From: Laura Black <[REDACTED]>
Sent: 15 October 2025 09:12
To: Jessica Riches
Subject: RE: P/127/25/DOC - Ecology Comments - Condition 15
Attachments: Land at Horns Lane, Pagham - EMMP & MLPP - Final (Oct, 25).pdf

From: Jonathan Best
Sent: 10 October 2025 11:31
To: Jessica Riches <Jessica.Riches@arun.gov.uk>
Subject: P/127/25/DOC pre submission comments

Figure 19. A schematic of how the Cambridge full face Swift brick leads into a cavity created by the prior installation of the Swift maxi nesting box.

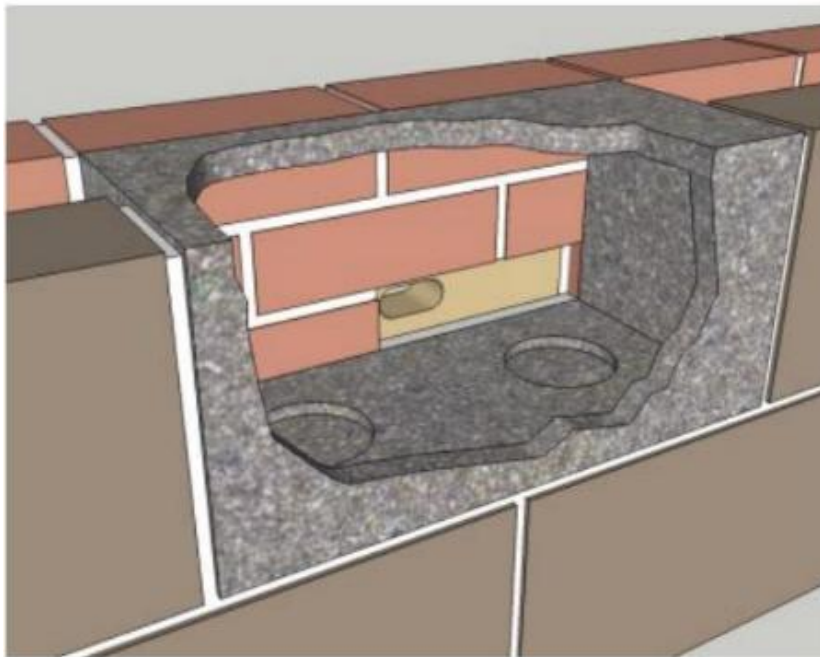
The EMMP states 'each of the new dwellings on site will have at least 1 No swift brick incorporated into the building'. The Cambridge Swift brick is fine. The CJ Maxi box referenced is not integral and should not be used.

Please see attached amended report which addresses the Ecology Officer's comments.
